Your Ref: OWPC18907
Our Ref: FG/95/18/HH 04-05-2018
Please ask for:
Andrew Wood

Two storey front extension, side/front first floor extension & replacement garage.
25 South Drive Ferring

REVISIONS:
A - High level window on west elevation to have obscure glazing and to be fixed shut.

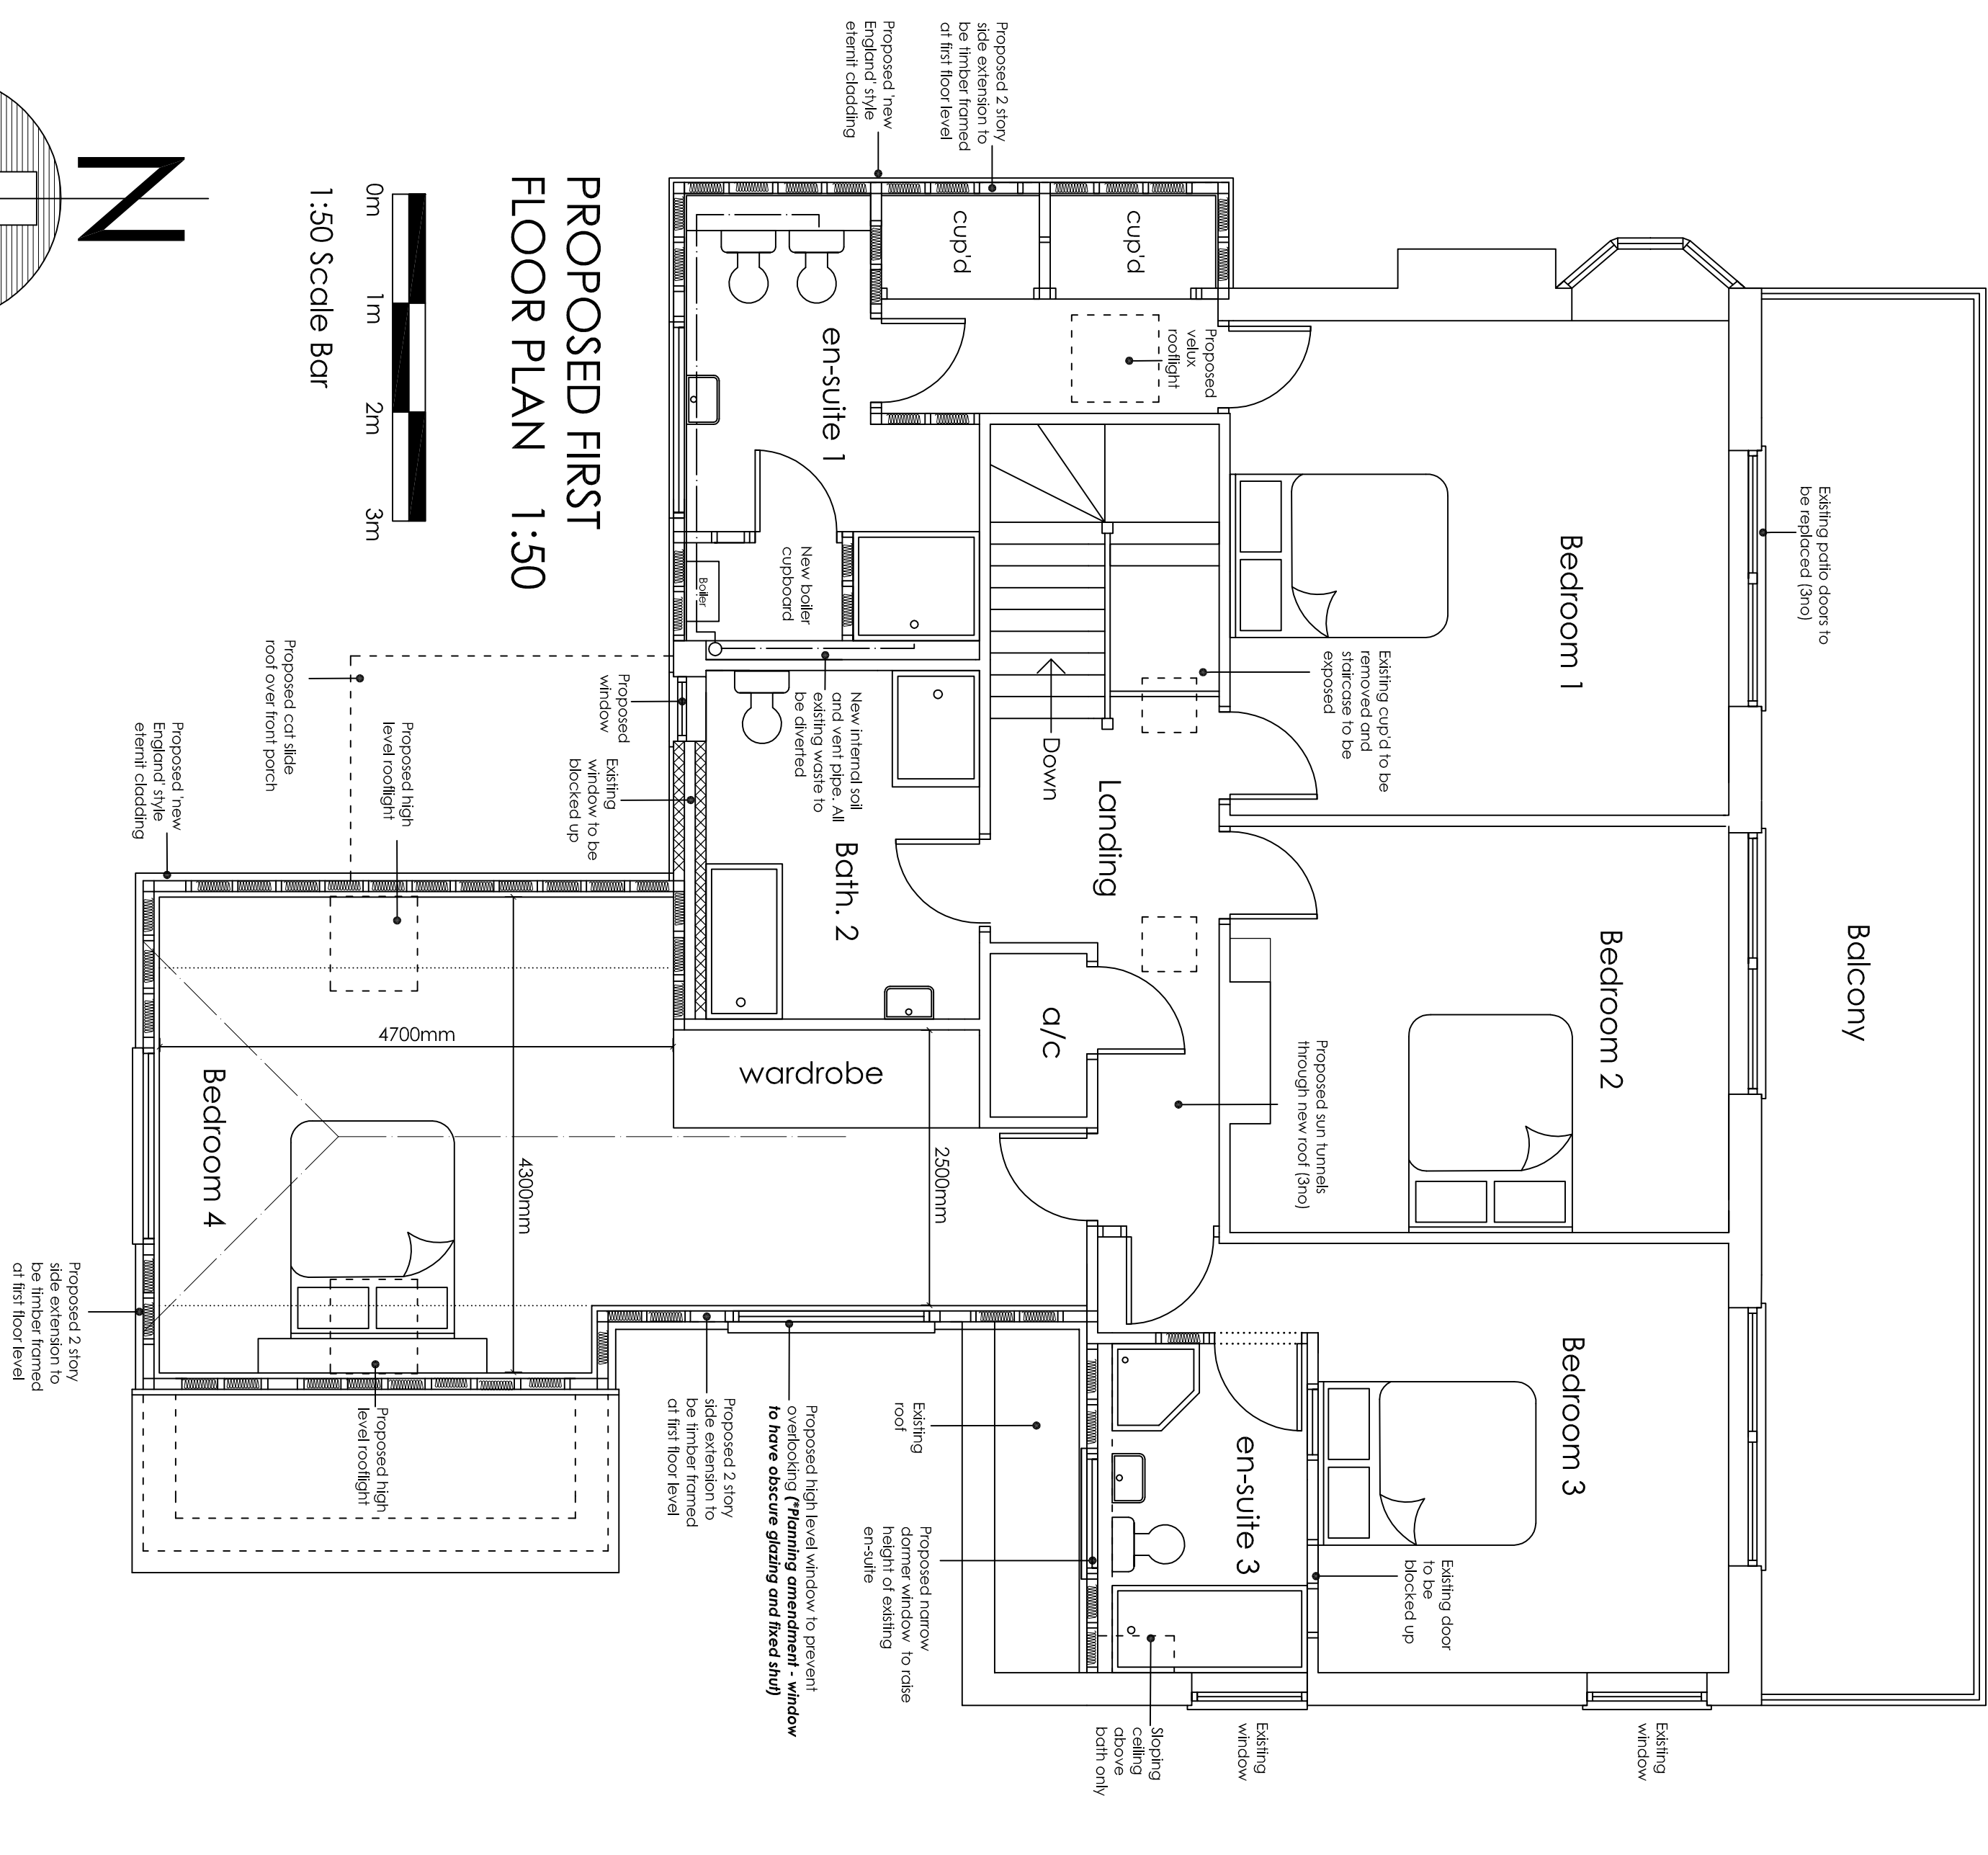
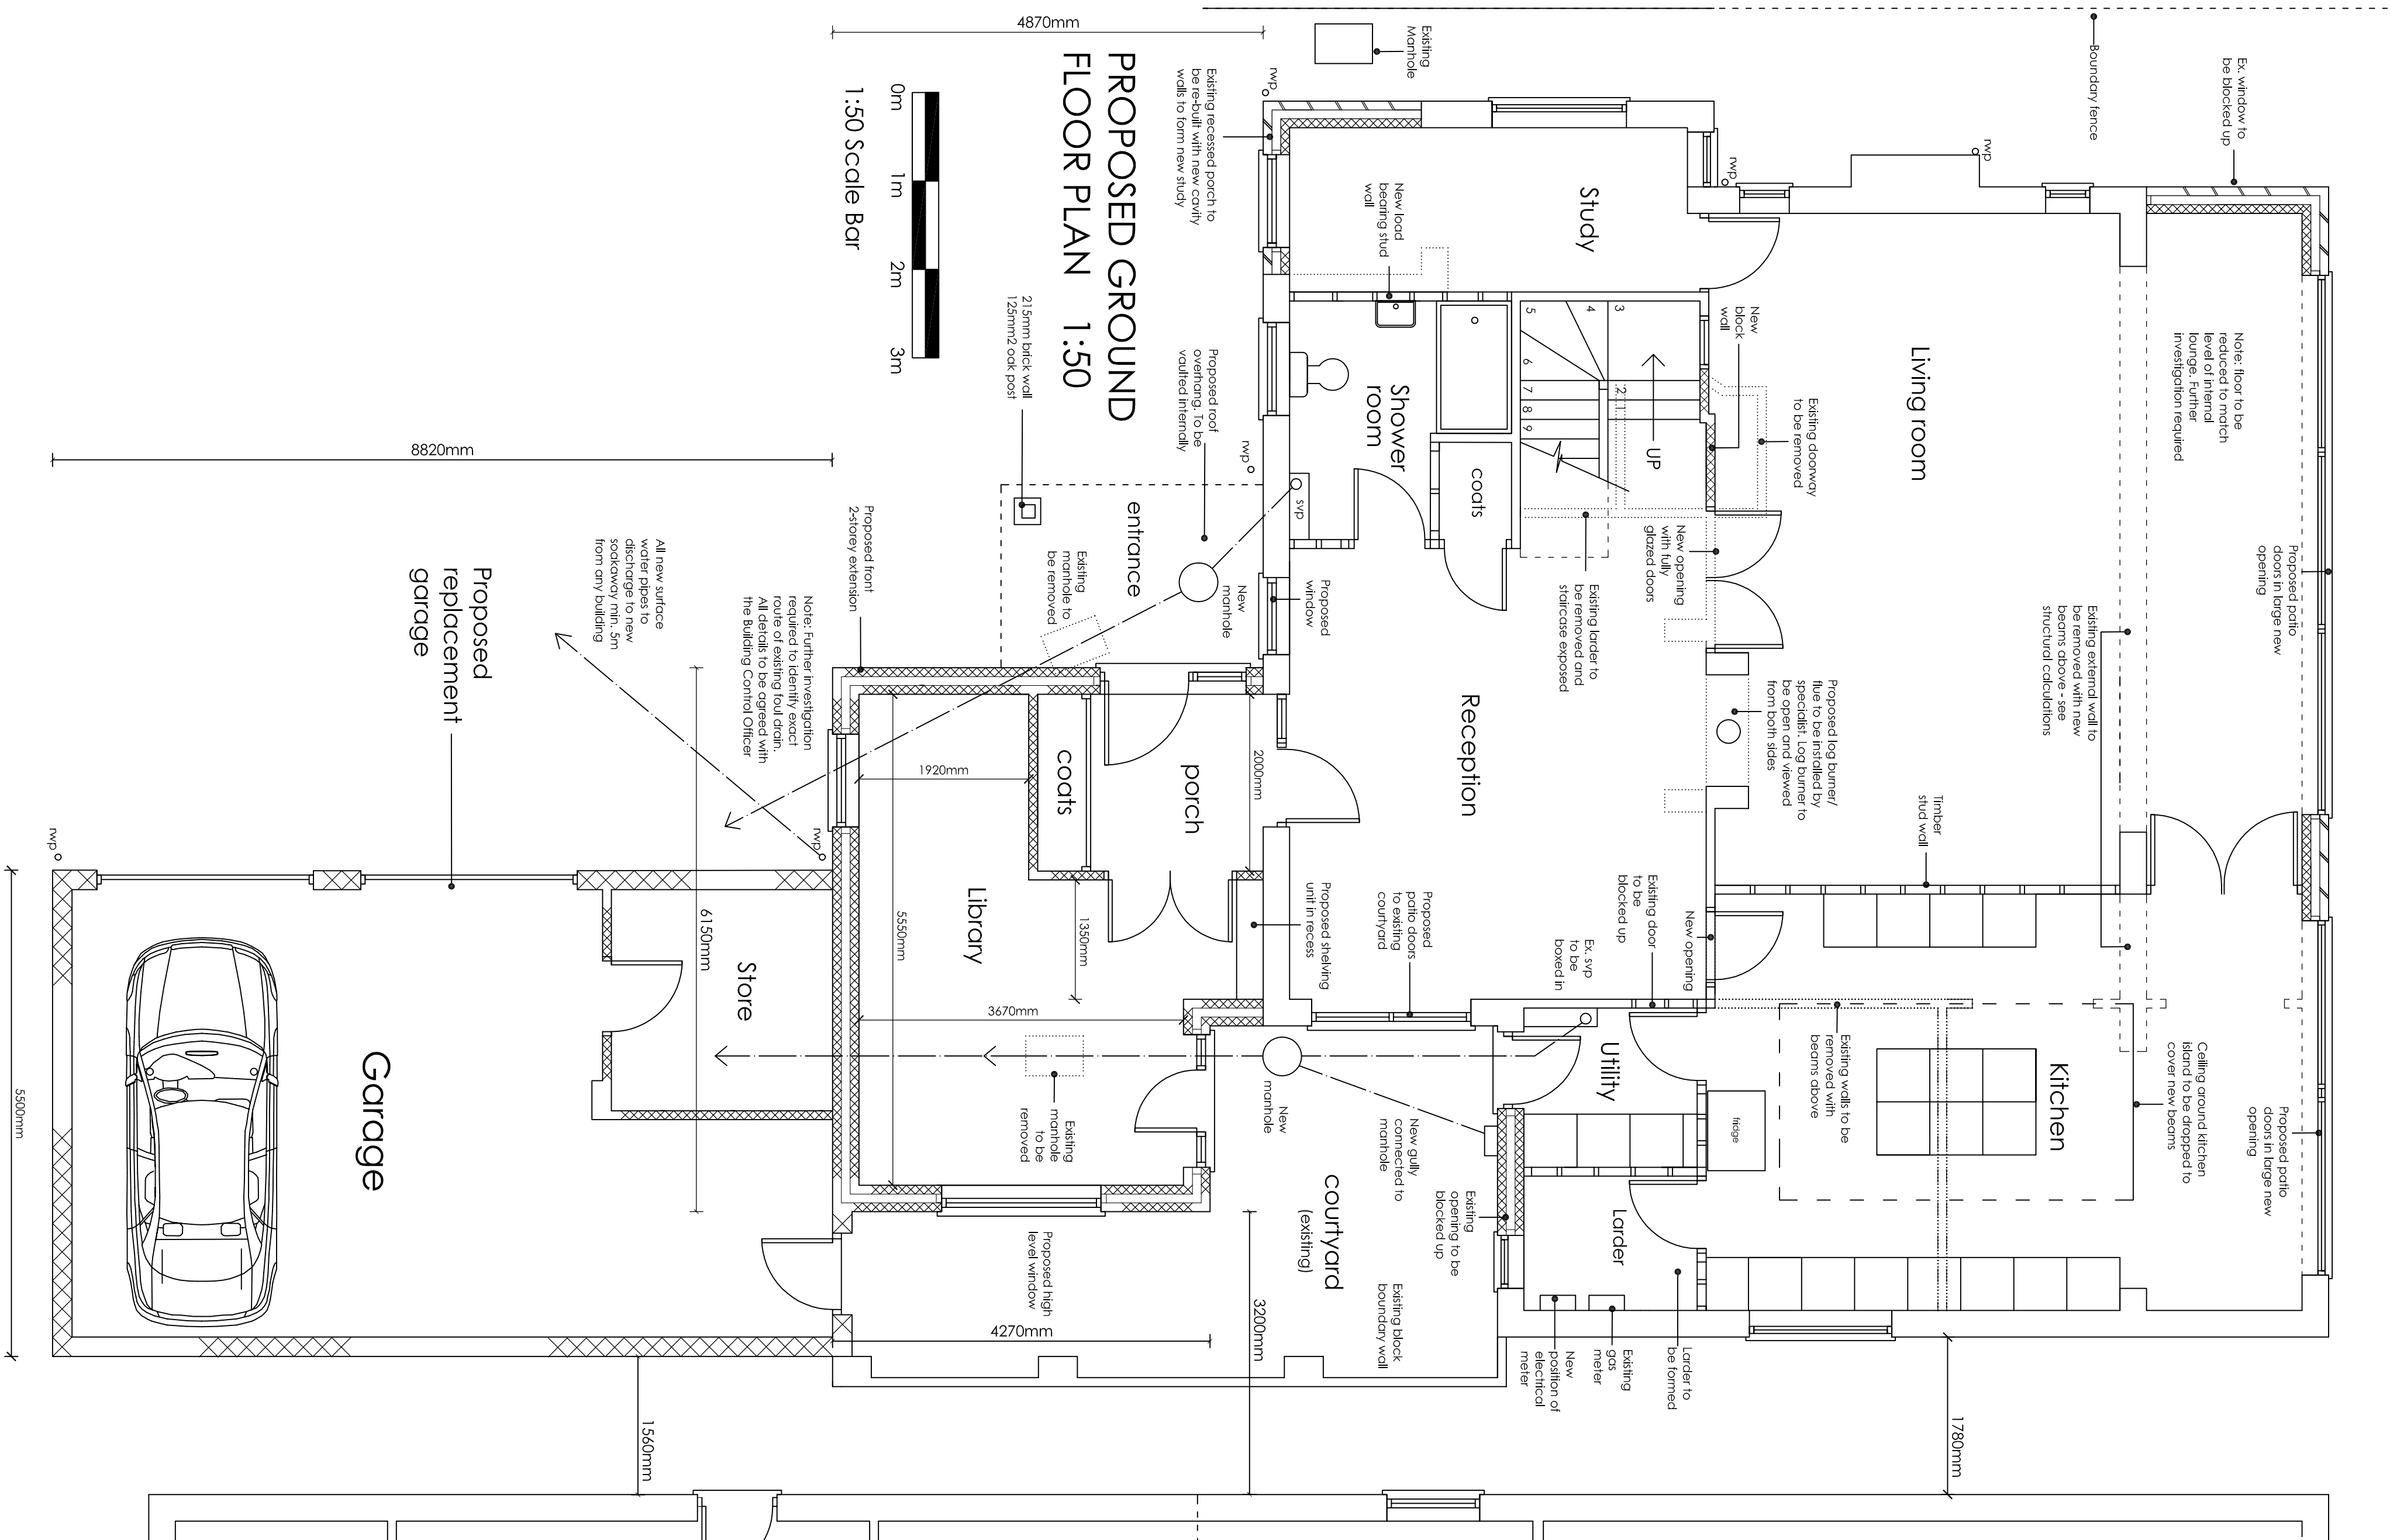
With regard to the proposed 2 storey extension to the front of the property we object to the high level window to Bedroom 4 on the West Elevation.

In the planning statement it mentions the 2.6m high boundary wall remaining and on the plans that this window is high level to prevent overlooking. On site, however, it can be seen that this window will indeed overlook our property in that it will have a line of sight over this wall and directly into our kitchen. This will obviously lead to a Loss of Privacy.

If this window were to be non opening and of obscure glass we would have no further objection.
